Dept of Planning & Infrastructure

My concerns regarding the proposed part Demolition & alteration and additions of Hurstville Private Hospital Application NO. MP11_0042 are as follows:

VIEW 6: PERSPECTIVE FROM REAR OF 10 MILLET ST - MOD 1

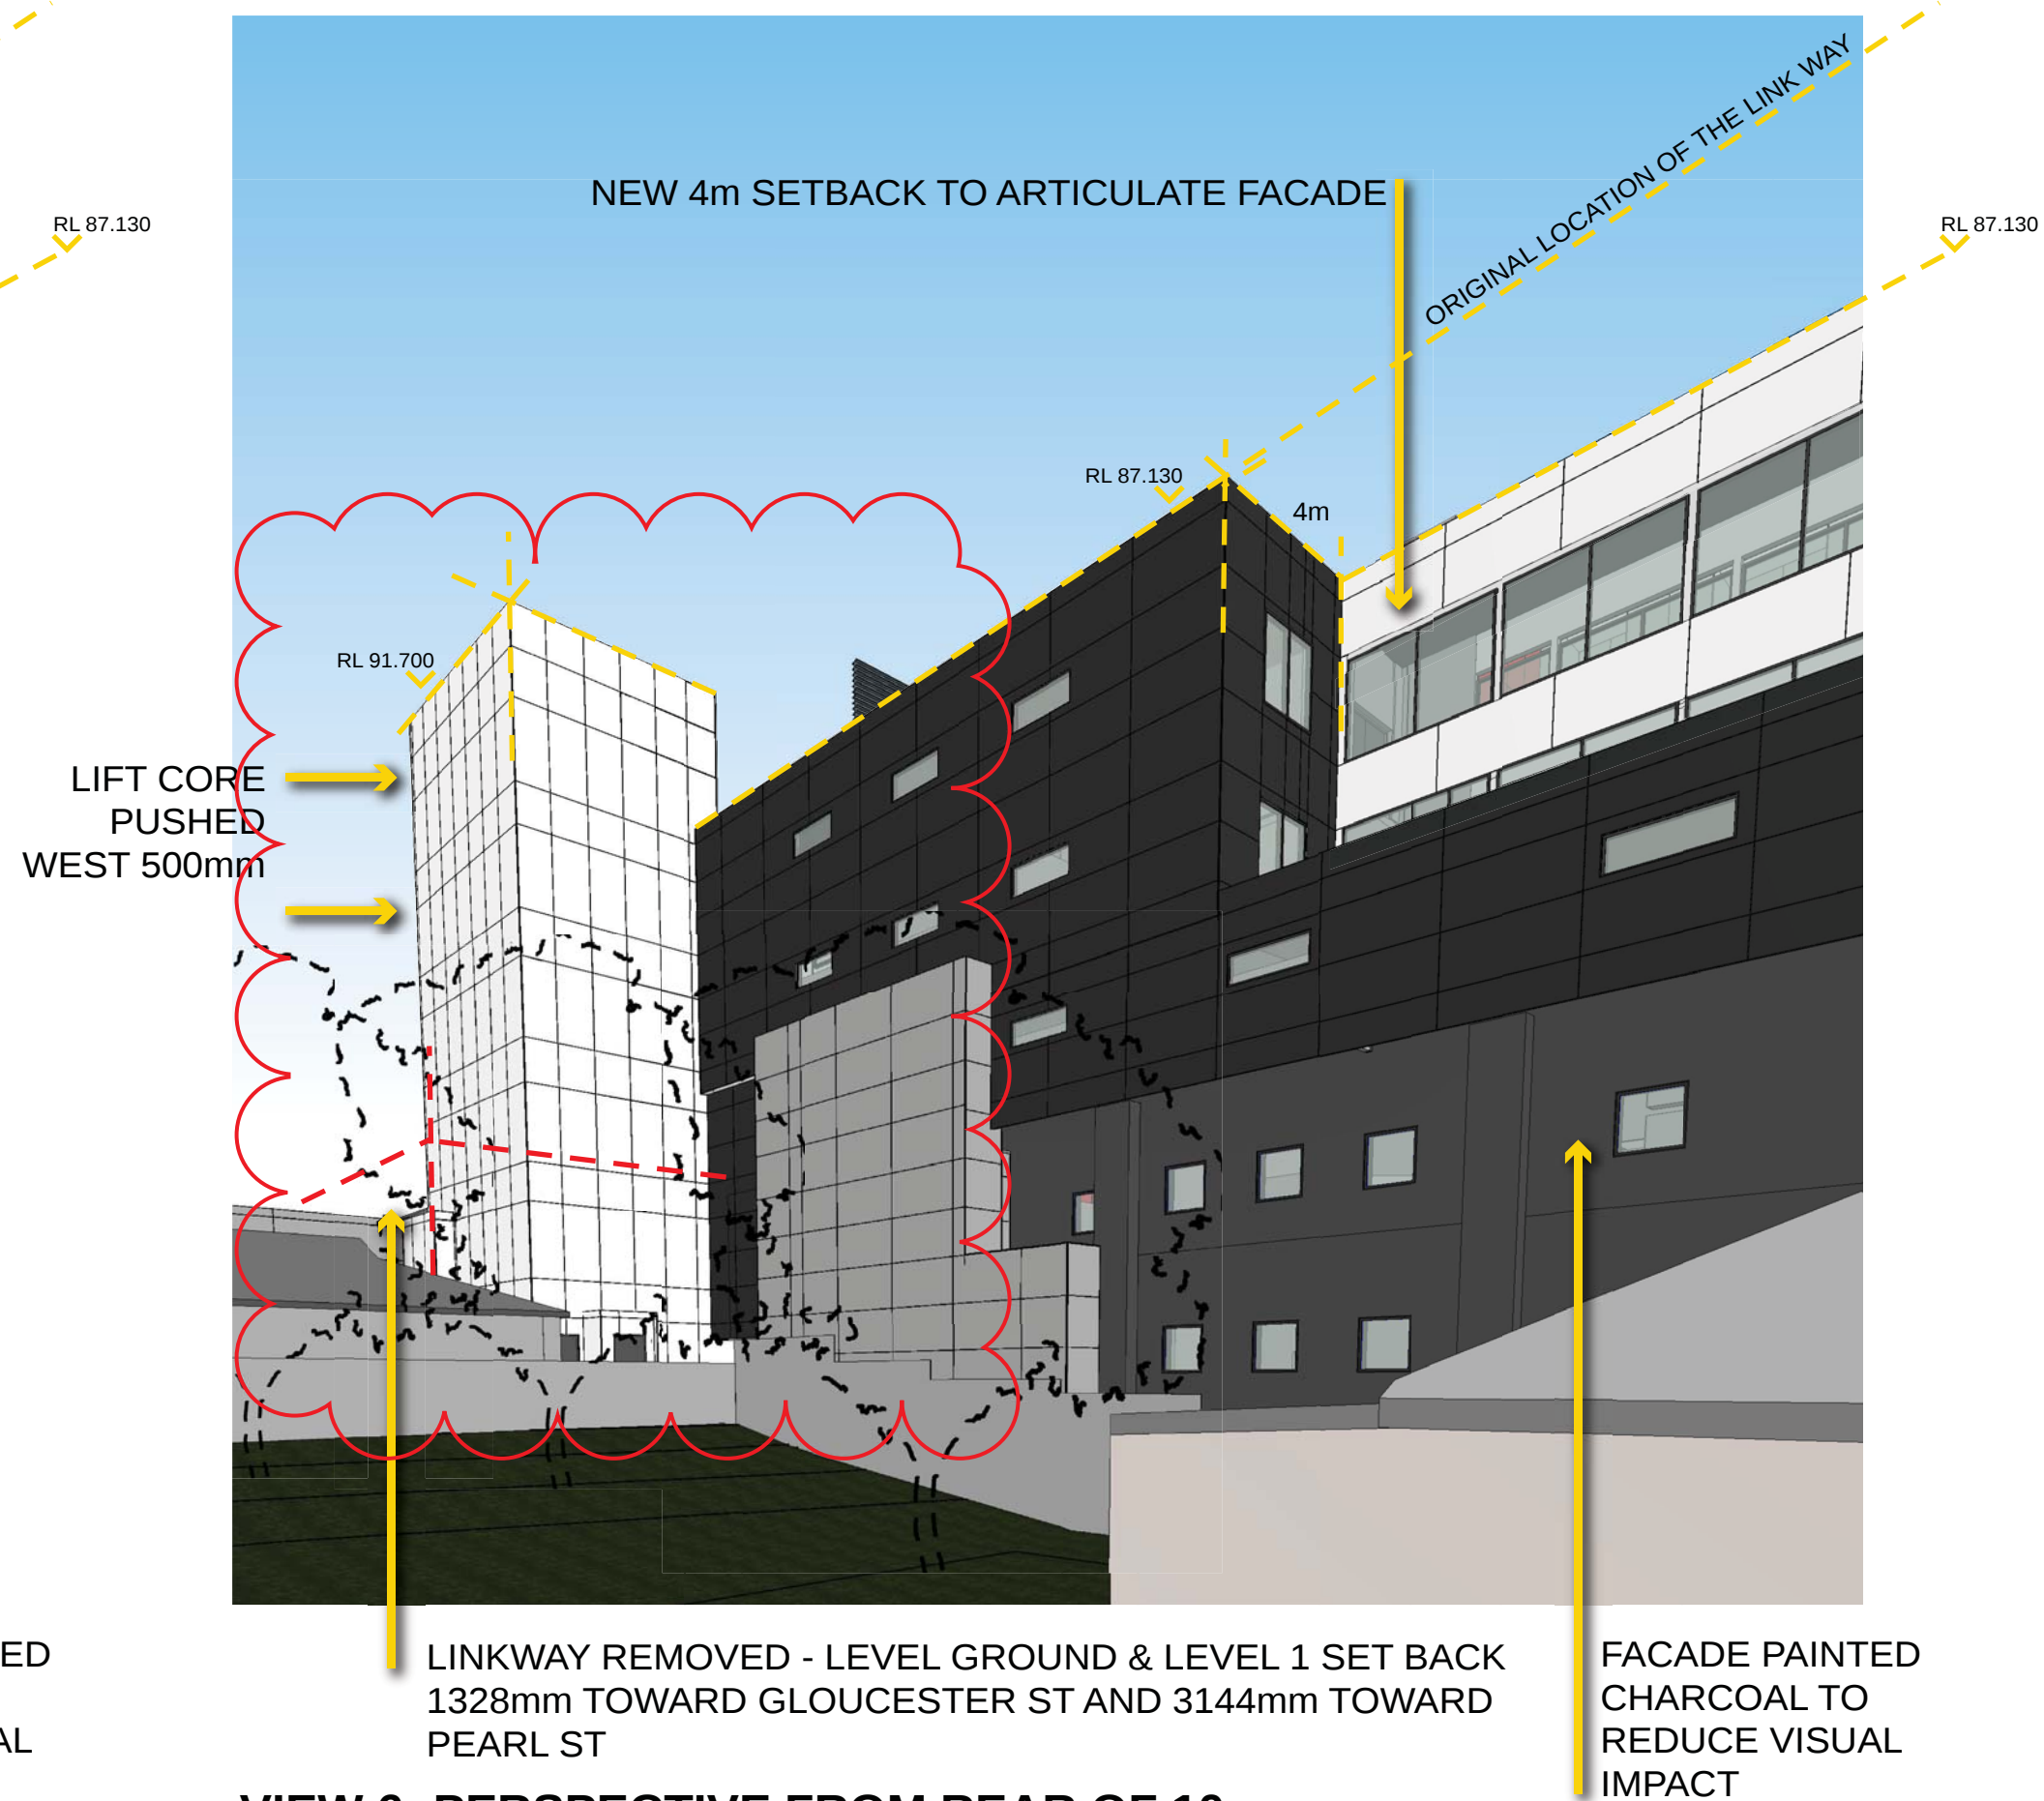
- 3.2 I am unable to find any clear documentation as to how this car park will be built, nor the impact on the surrounding residential area, nor how high it will be, nor if it will have a roof. I am able to find colourful pictures of how the main building will look with proposed landscape, however no projected pictures of how this extension to the car park behind the hospital will look. How can I agree to something that is unclear?

- 3.4 I strongly object to any extension to the car park at the back of the main building as it appears to encroach on airspace over 12 Millett Street. The local residents in the villas at no. 10 & 16 will have their privacy invaded by persons entering or hanging around the area of this car park.

- 3.5 I objected to council about our privacy when the car park was originally planned at number 12 Millett Street, and was assured that the incline and fencing would give us adequate privacy and the fauna planted would reduce the noise. To put further parking above the top end of the incline would not only allow unlimited views onto all our verandas, but also complete views into every window (bedrooms as well as lounge rooms) facing the car park. If a suggestion of a higher fence would solve this problem, is very naive as it would be displeasing to the eye, and give the impression of being imprisoned, as well as reduce the current sunlight enjoyed by the properties on either side of 12 Millett Street.
